Memorandum

To DEVELOPMENT, HERITAGE AND ENVIRONMENT MANAGER Ref:2019/0366
From ENVIRONMENTAL HEALTH MANAGER Ref:
Subject 2019/0366/FUL JA/255620
Date 9 December 2019

APPENDIX B: Existing Noise Sensitive Receptors

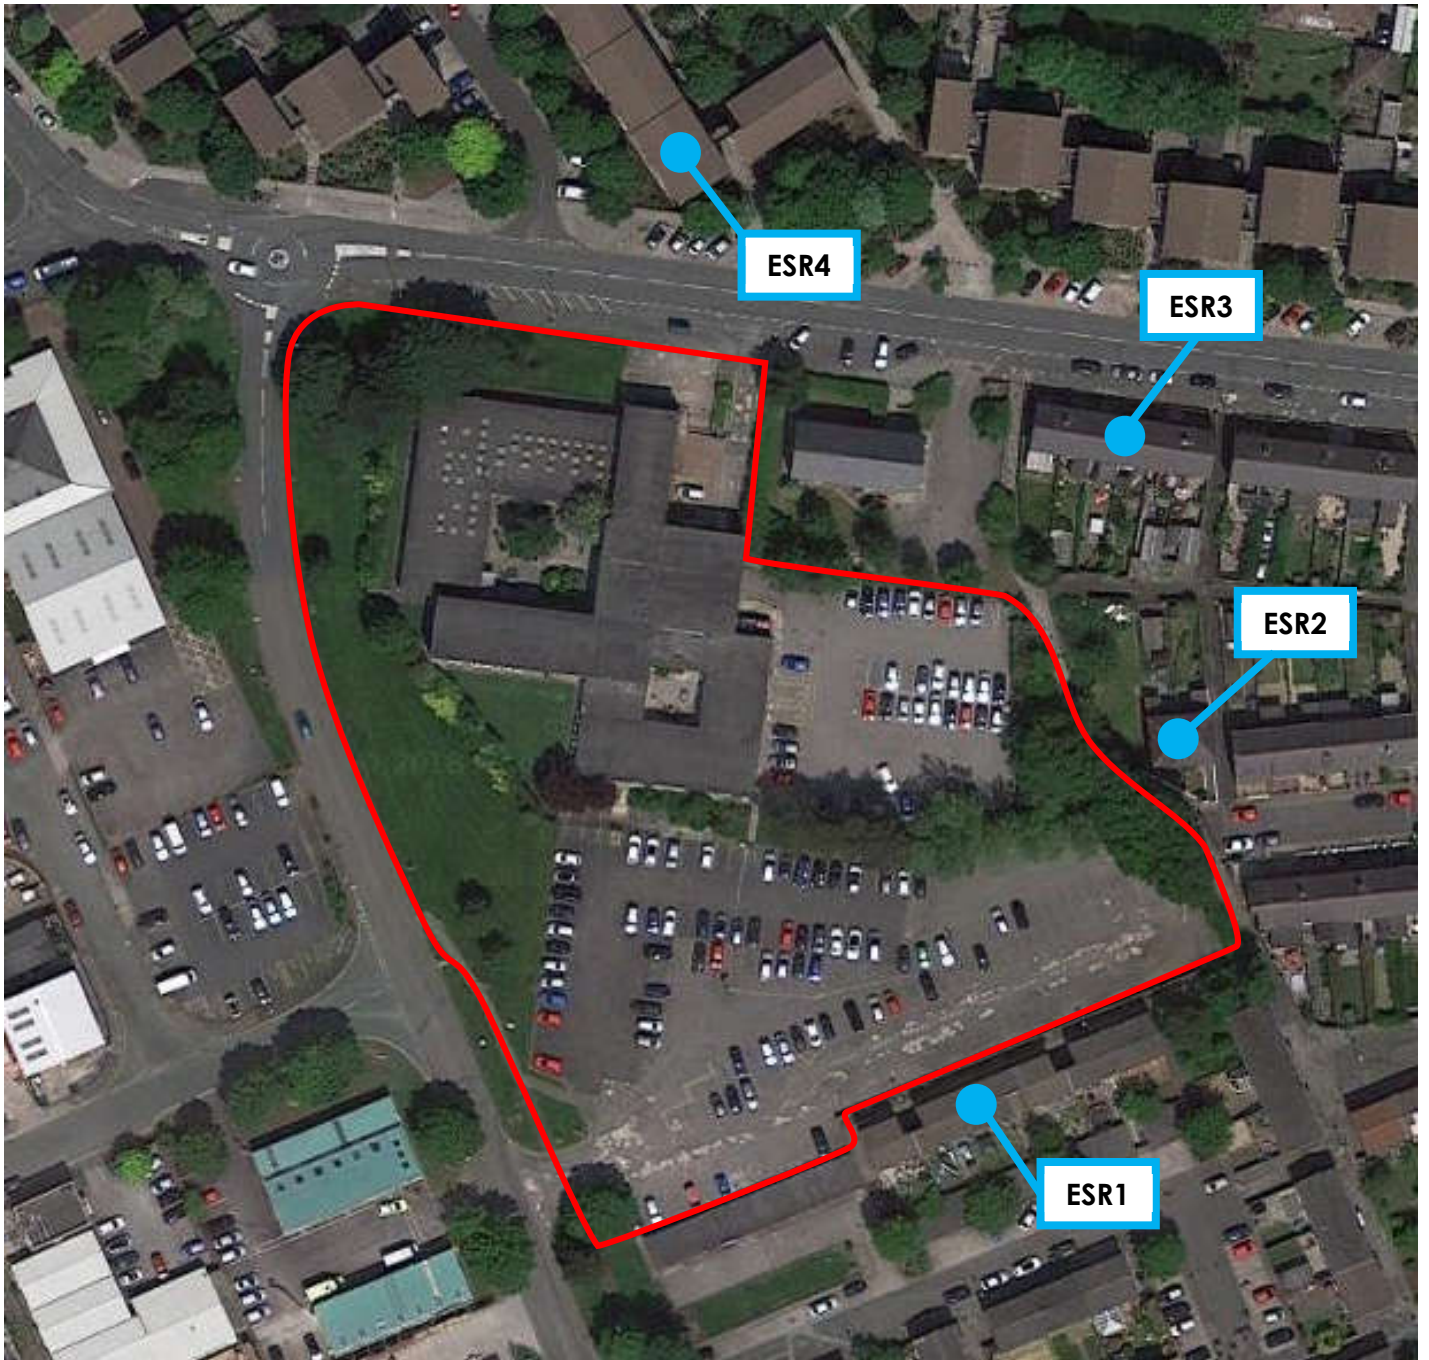
- Servicing can occur at any time during a 24-hour period.
- A single HGV would visit site in a worst-case 15-minute period between 23:00 – 07:00.
- A single HGV would visit site in a worst-case hourly period between 07:00 – 23:00hrs.
- The nearest noise sensitive receptors relative to the loading bay are 20m to the east.
- Partial screening will be provided by the installation of a dock levelling system.

In practice HGVs pass within about 7m of the façade of residential dwellings on Waldron, then reverse into the loading bay then leave again the same route.

The HGV Arriving/Departing SEL at 10m is 87dB(A). No LAmax figures are provided. The HGV will pass as close as 7m from the bedroom windows. Regardless of the calculated LAeq over 10mins, there is still an HGV passing within 7m of a bedroom window twice within a 15 min period as well as manoeuvring, reversing and delivery noise between these two events (no reversing alarm information is provided but white noise reversing alarms are advised).

This is likely to cause sleep disturbance and there could be more than one delivery per night.

I therefore would object to Aldi having deliveries within the night-time period and advise a condition requiring daytime deliveries only.

- The food store shall not be open for customers outside the hours of 0800 to 2300 on any day.
- No loading/unloading of vehicles and no deliveries shall be taken at or dispatched from the food store (including waste collections) outside the following times 0700 to 2300 on any day.
- The engine and any diesel-powered freezer/refrigeration unit on delivery vehicles serving the food store shall be turned off and kept off, whilst the vehicle is stationary.
- The rating level of noise from fixed plant on the food store site shall not exceed 46dB(A) daytime and 40dB(A) night-time as measured or calculated at the façade of any nearby residential premises. All measurements and assessments shall be done in accordance with BS4142:2014 Methods for rating and assessing industrial and commercial sound.
